# CITY OF ALBUQUERQUE

**Re: Ventana Ranch Community Park, Drainage Management Plan  
Engineer's Stamp Date 3/29/12 (B10/D003)**

MASTER DEVELOPMENT PLAN  
DRAINAGE MANAGEMENT PLAN

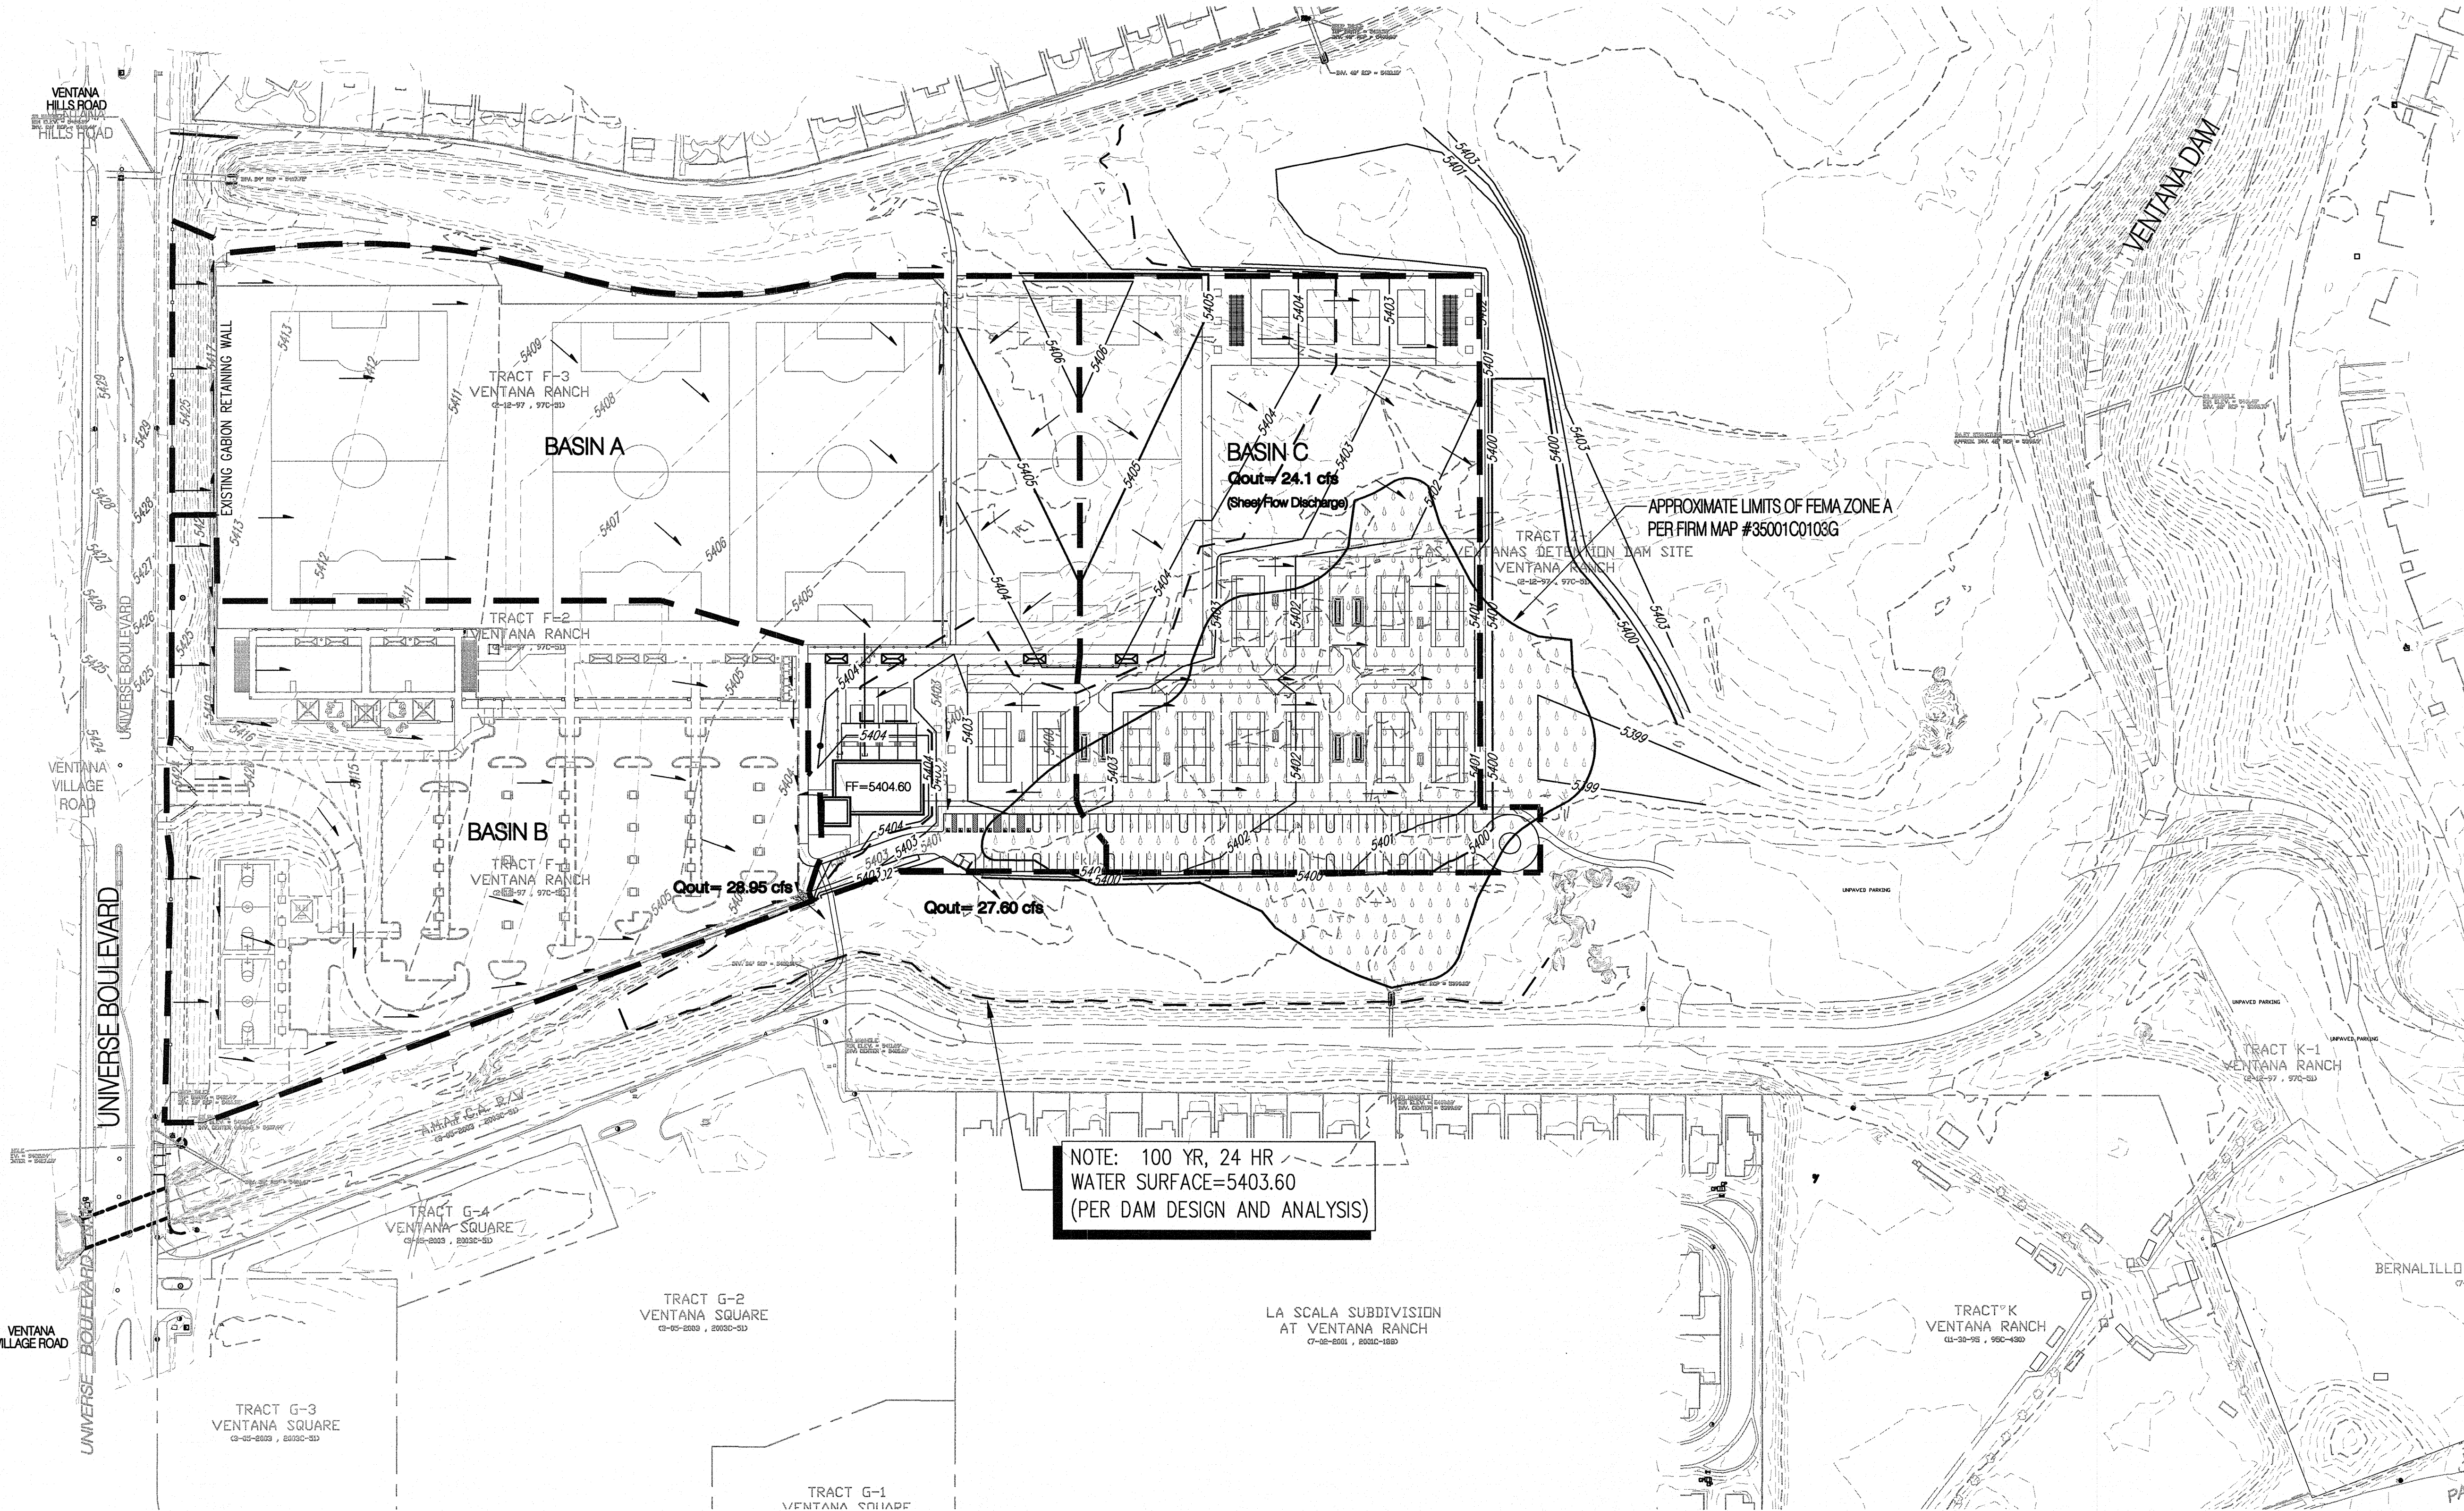
- AMAFCA approval is required.
- Show the Zone A flood zone. The proposed building must be outside the limits of the flood zone or a LOMR will be required.
- Are the pedestrian crossings across the arroyos grade separated?
